Angmering On Sea Estate Residents' Association Ltd

Ms A Gardner
Planning Department
Arun District Council
Maltravers Road
Littlehampton
BN17 5LF

Re: EP/136/18/PL – Tudor Lodge, Sea Road, BN16 1NX

The aforementioned property is located immediately adjacent to the Angmering on Sea Estate. The Residents' Association of the Estate wishes to register its **OBJECTION** to the proposed "variation of condition 2 imposed under EP/59/17/PL relating to approved plans concerning updated site plan & ground floor plan".

Ground Floor Plans

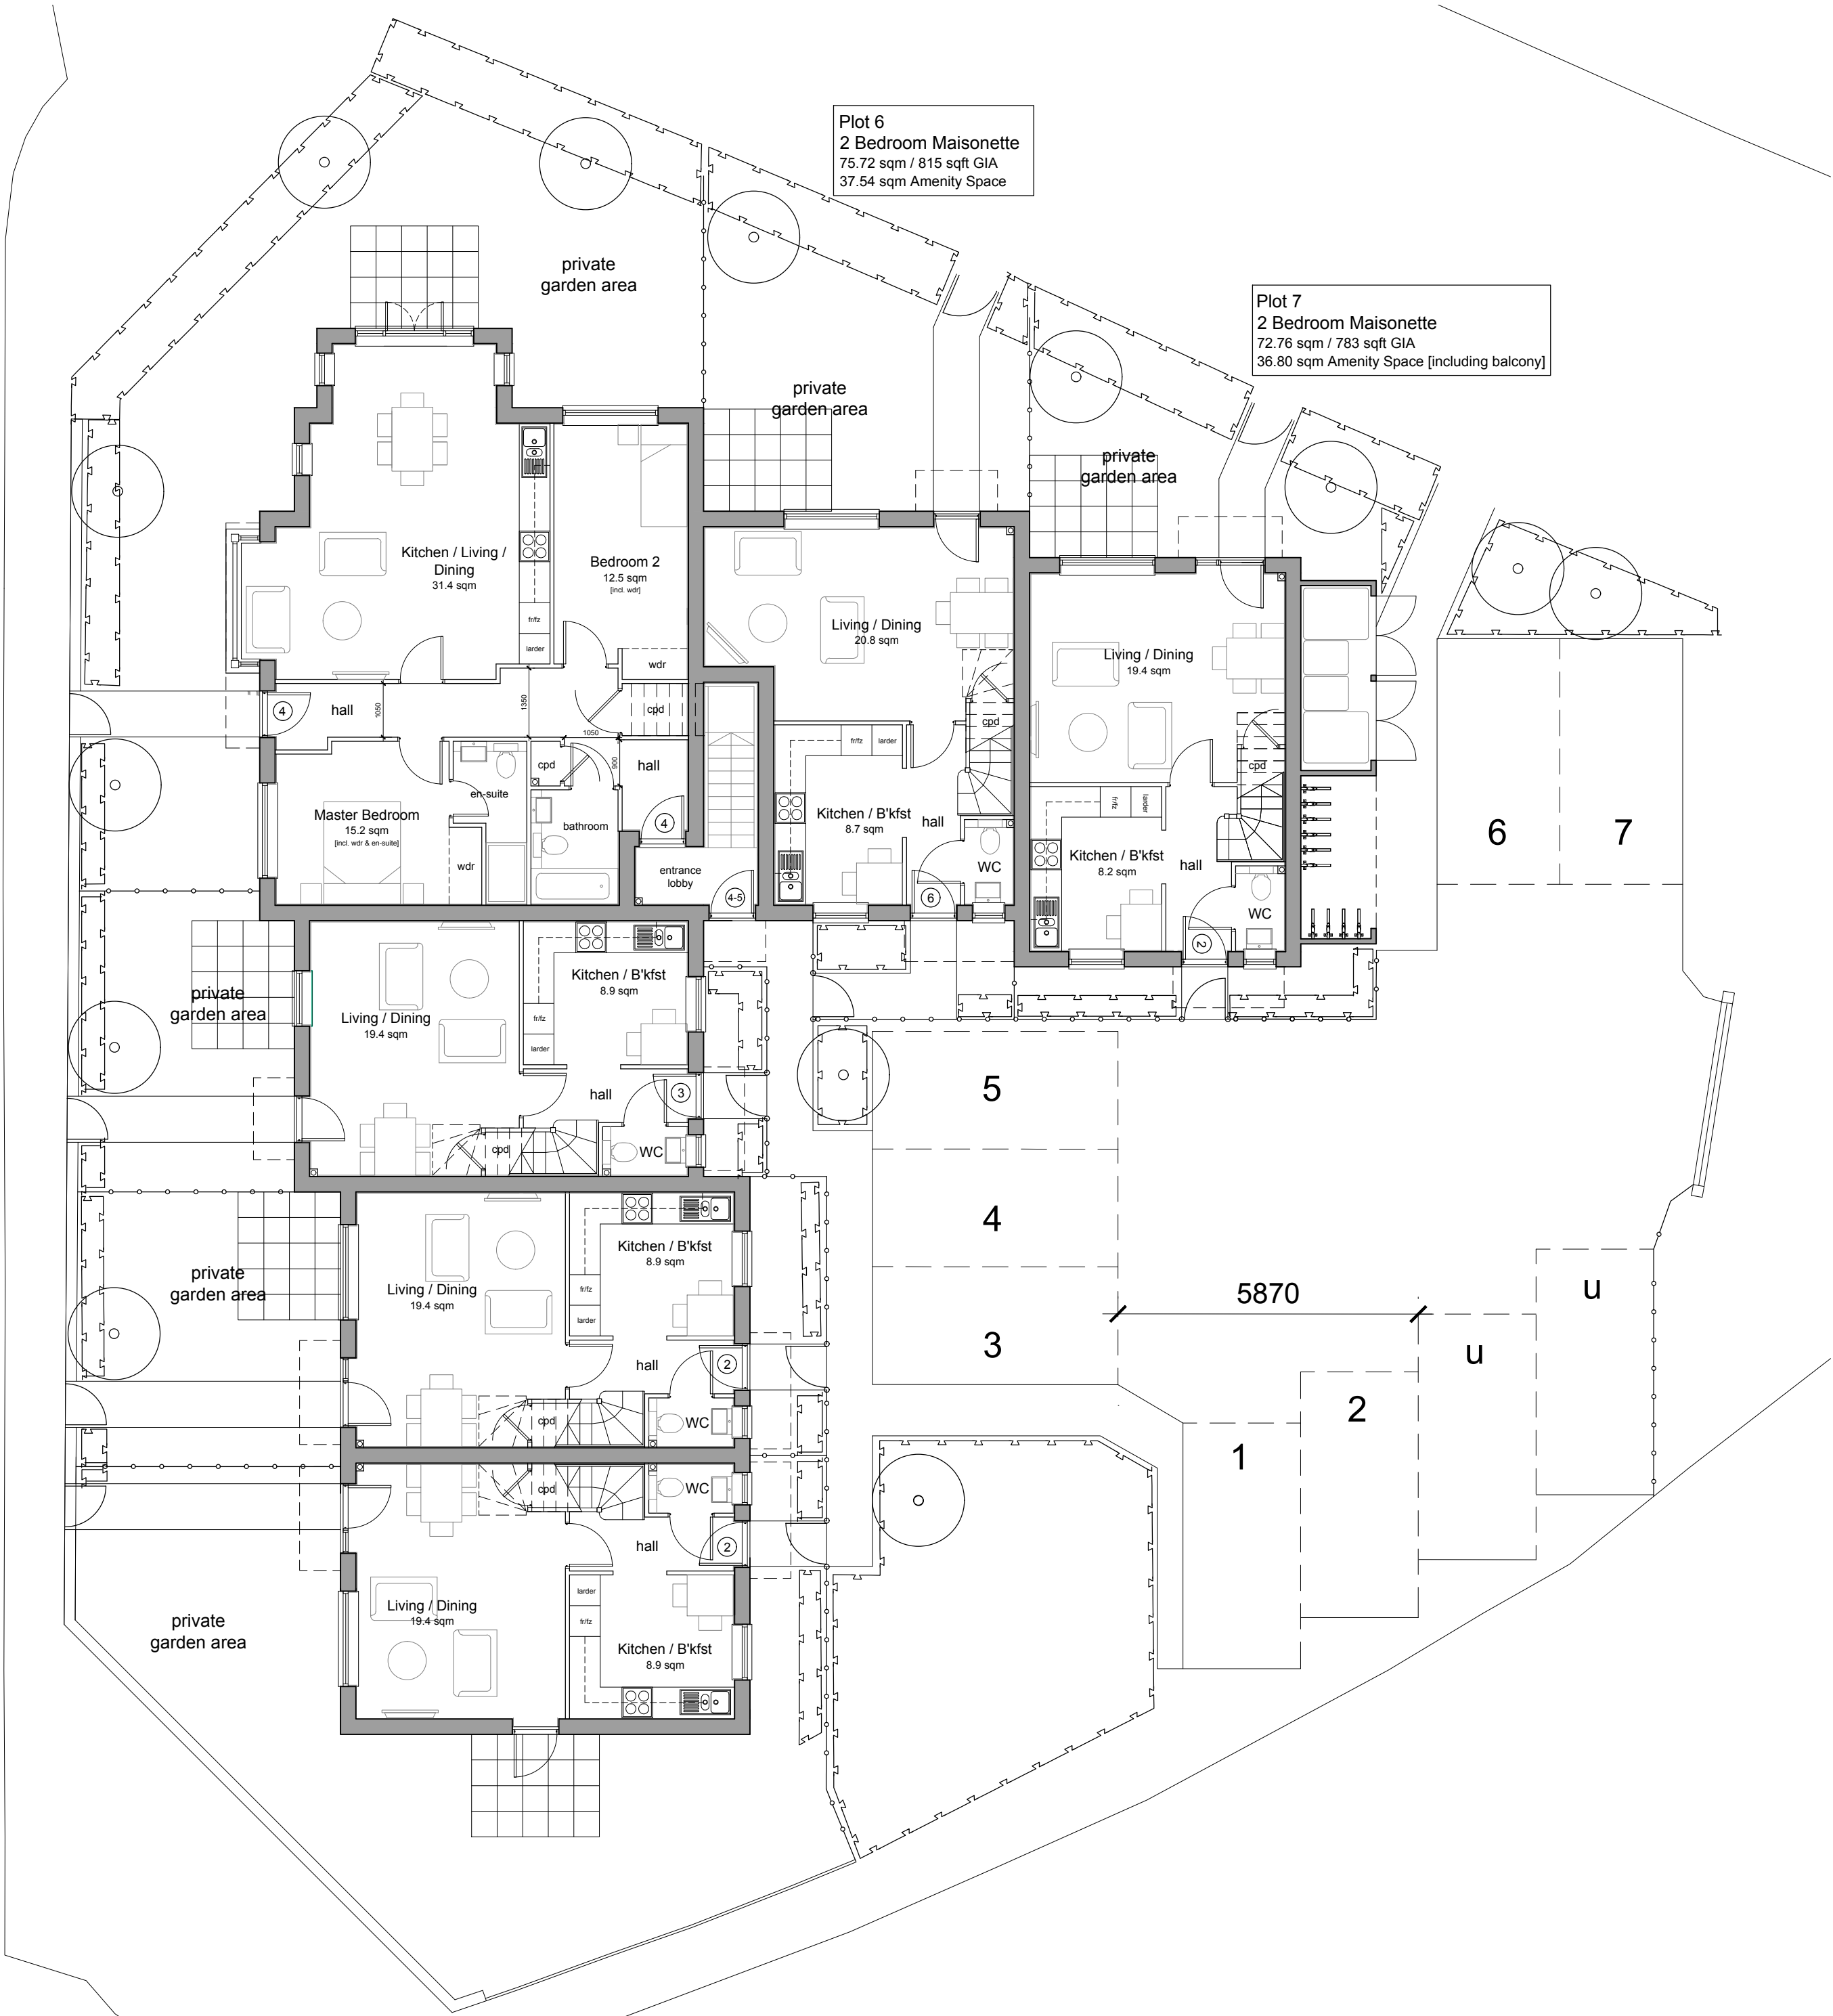
Rocco Homes proposed changes have greatest impact upon the entrance and exit to the parking area at the rear of the development. From our perspective this has considerable impact upon our residents living in Palm Court Cottages. Since the development began the site and delivery vehicles – some very large – gain access to the site directly from South Strand (see photo below). "The Vehicle Paths plan drawing – L2340-C-95-100 01" (see extract below) depicts the path of vehicles entering and exiting the parking area as being into and out of Palm Court Cottages and not the area presently used by the delivery vehicles. There is no valid reason for this to be the case - if the large delivery vehicles can use the South Strand entrance then so can the residents.

This small variation in Rocco Home's plan will go some way to alleviating the worry and distress caused to our residents.
